From: Adrian Dowd
Sent: 08 June 2022 10:53
To: Planning
Cc: Kathryn Hughes
Subject: FW: Consultation on planning application, 3/2022/0465, Post Office 1-3 Bridge Road Chatburn BB7 4AW
Attachments: 22 0465 Email Consultation.pdf
Categories: To Upload

The application is for - Proposed first floor change of use to three self-contained flats, access via external staircase. Ground floor conversion of store buildings 1 and 2 into a kitchen.

proposed north elevation

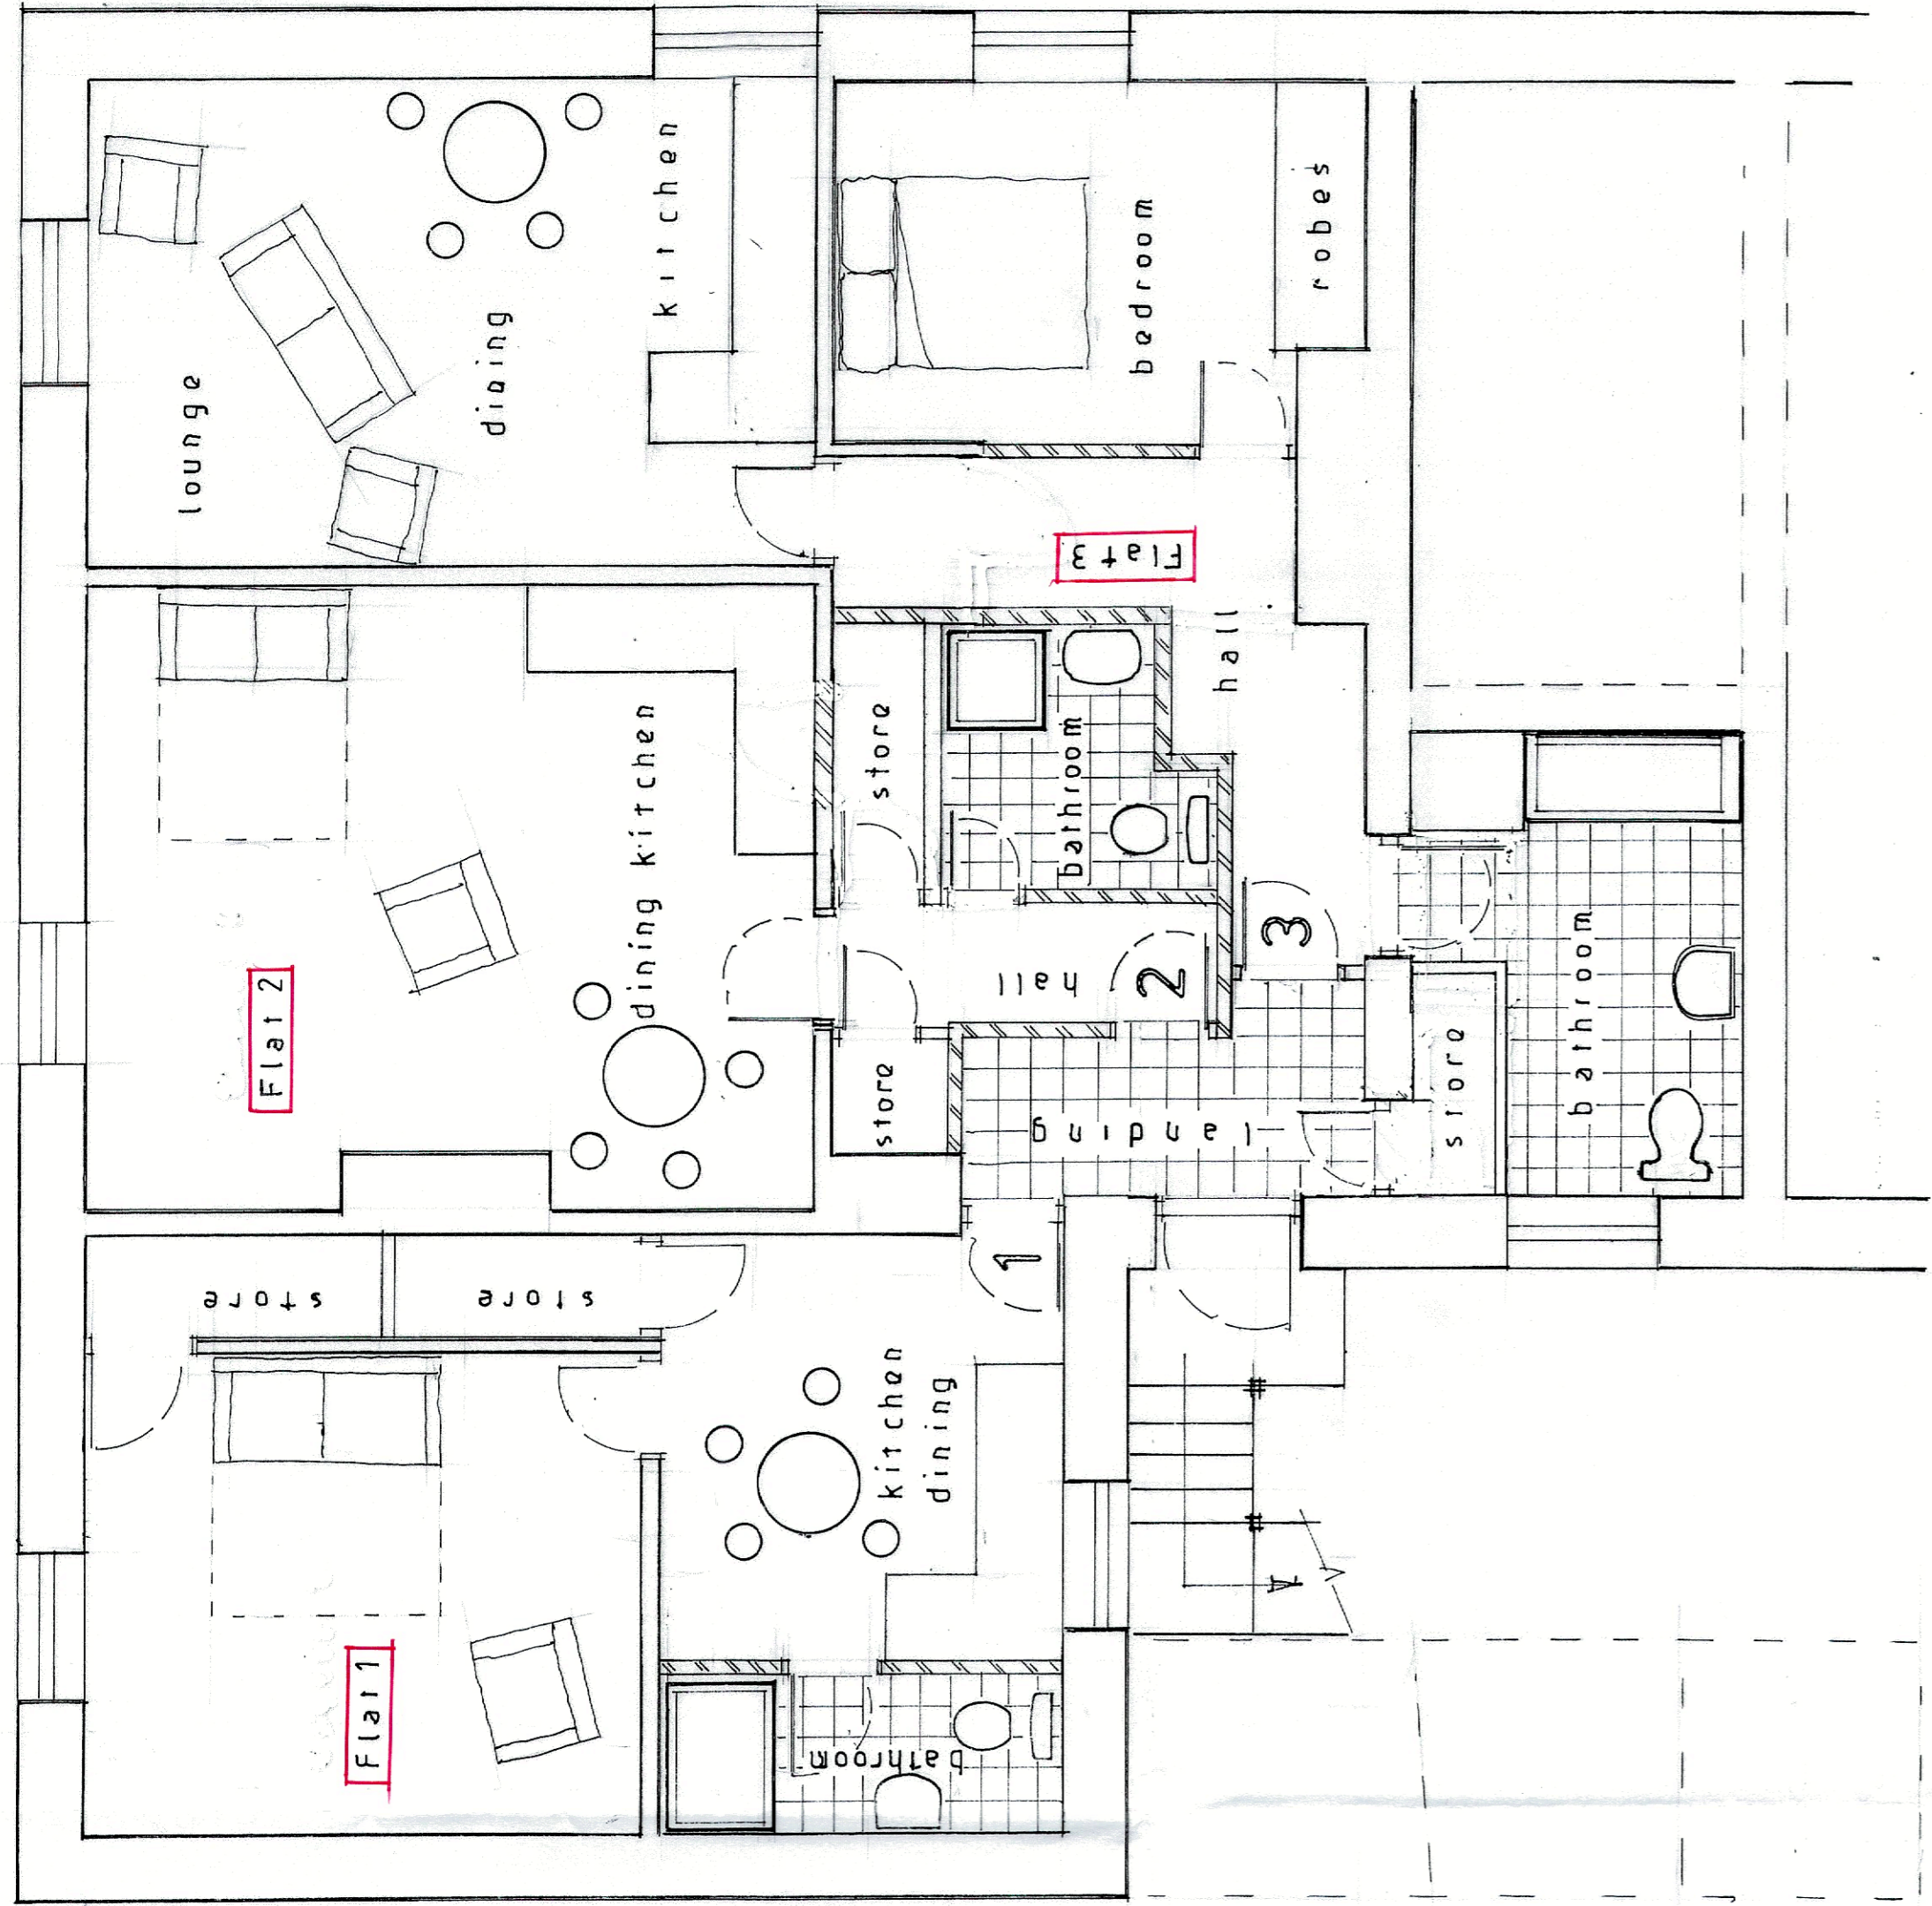
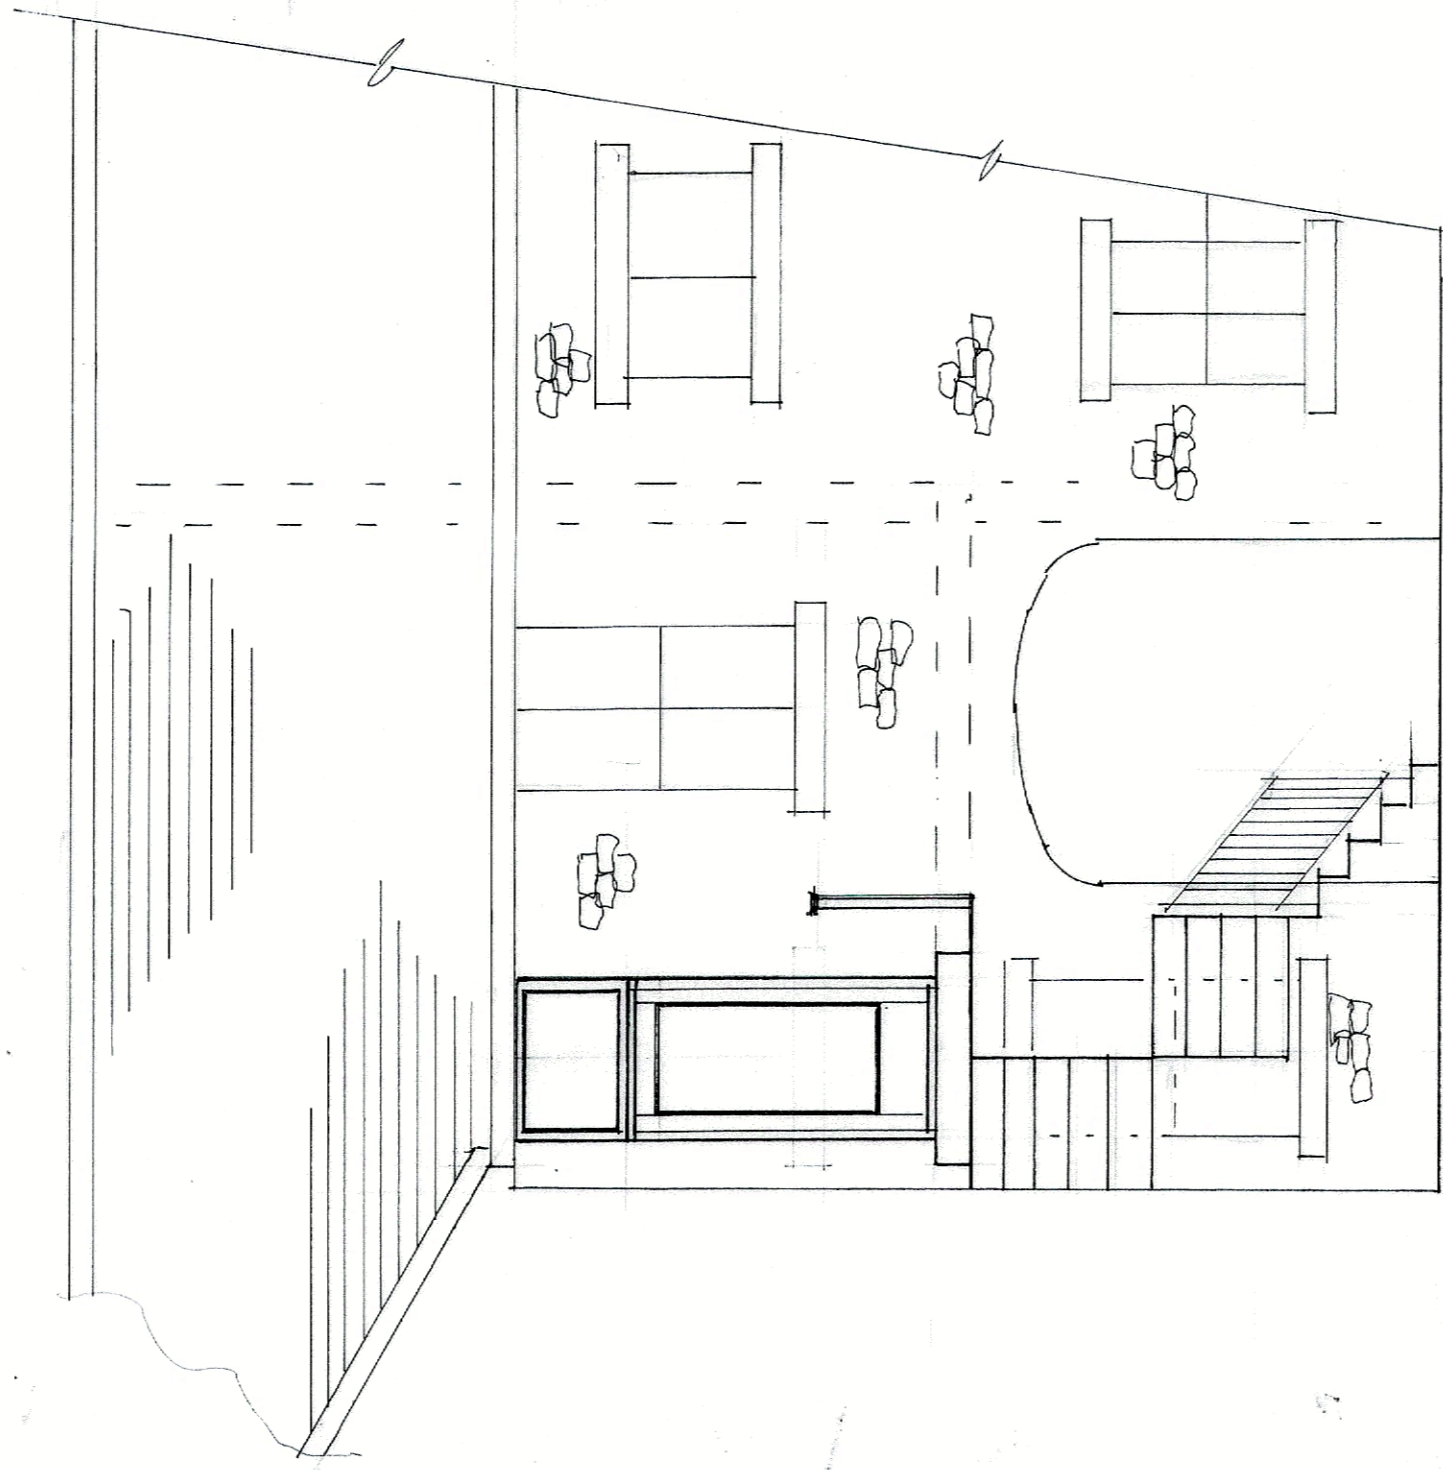
Happy to advise on any particular elements of concern. Are first floor doorways sympathetic to the character and appearance of the building/conservation area?
